**Consultation Response from Alan Smith,
KC Waste Strategy (Refuse & Recycling)**

2025/92204 329, Bradford Road, Fartown, Huddersfield, HD1 6ER

Change of use of basement and ground floor to fast food outlet with seating

Date Responded: 02/09/2025

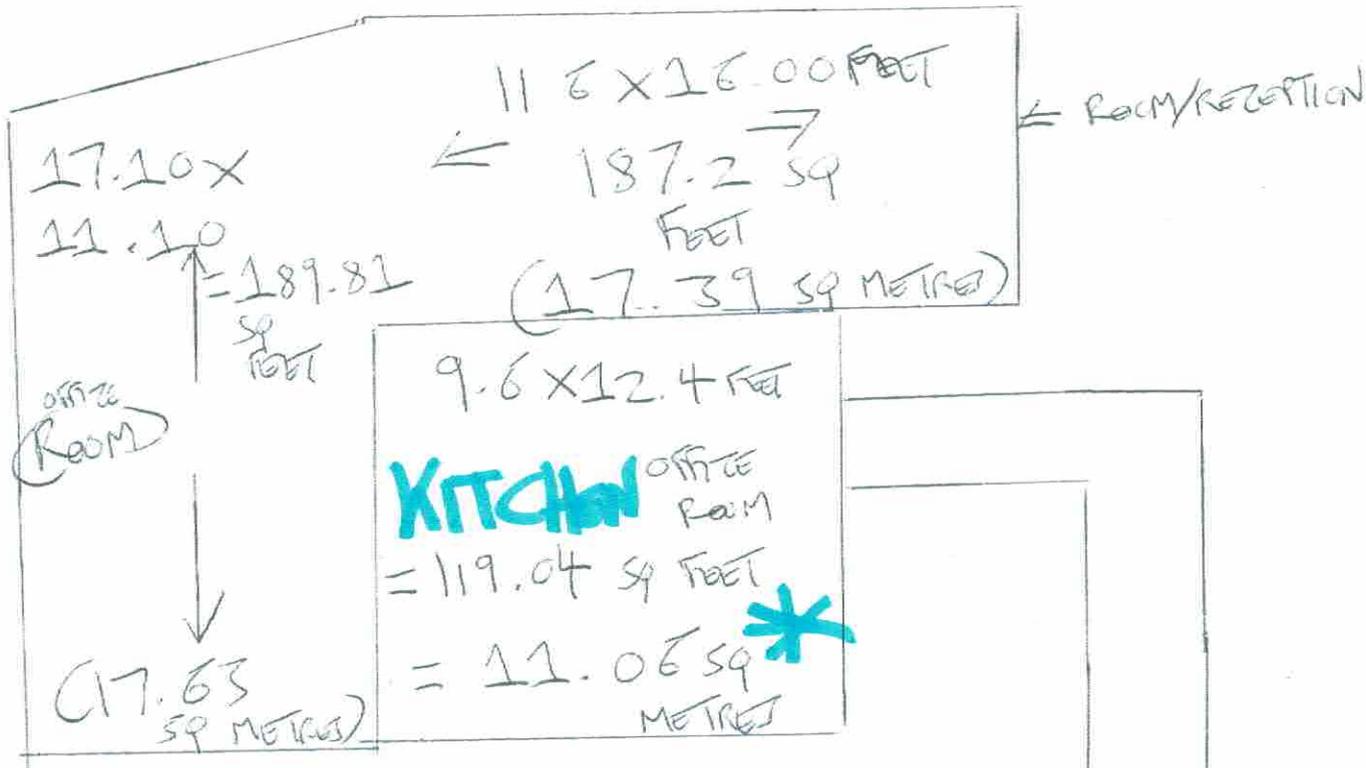
The applicant has submitted a "proposed floor plan", but this does not include any details about the location of bin storage or Bin Collection Point (BCP).

Bin storage on the footway on Bradford Road at the front of the takeaway or on Spaines Road would be unacceptable.

- The bins should be contained within a purpose designed store at this site that may be internal to the building with access directly onto Bradford Road or Spaines Road. Details of bin store construction requirements including screening can be found in the Kirklees Waste Management Design Guide 2020. The bin store should be secure to prevent theft, unauthorised use/ fly tipping, arson or rough sleeping. The bins should not be sited near any windows or doors due to the risk of fire.

- A temporary BCP for use on the collection day should be shown on the site plan. The drag out distance for wheeled bins from a bin store/ premises to the collection vehicle should preferably be under 15m.
